Planning Application No: 3/2025/0049

Proposal: Two storey rear and side extension including rear balcony.

Location: Megitta House Kenyon Lane Langho BB6 8AN

The plans and submitted documents have been viewed and the following comments are made.

Scale	1:200 @ A3	Drawing No.	Rev.
Date	10/01/2025	D0275/105	-
Dwg By	MA

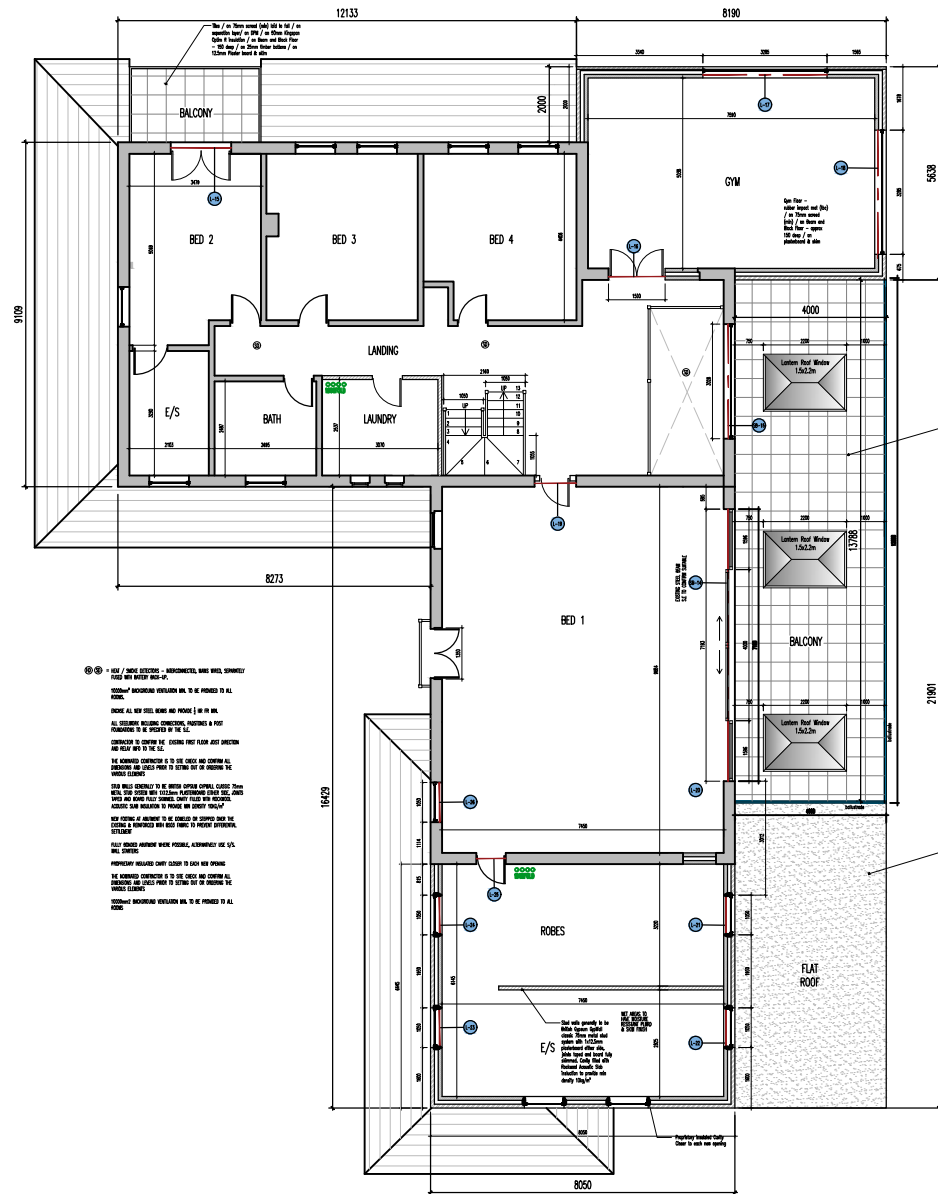
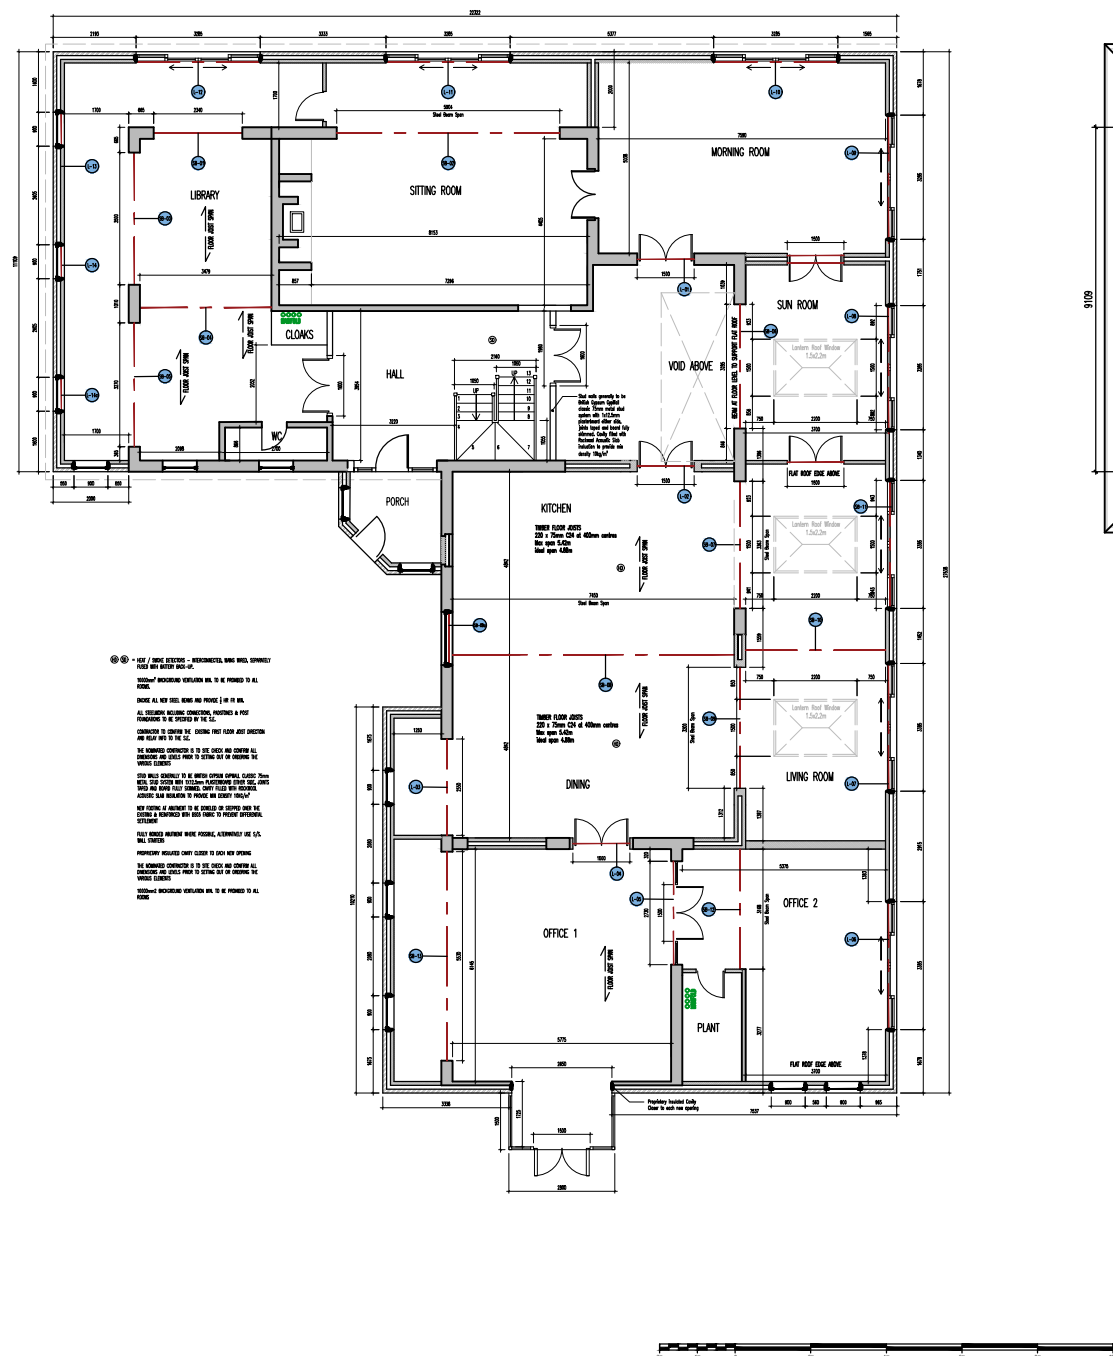
There is no change to access with this proposal, and existing parking arrangements are not affected. It is noted the gym ref drawing no. D0275/105 (10/1/25) will only be used for the enjoyment of the existing householders.
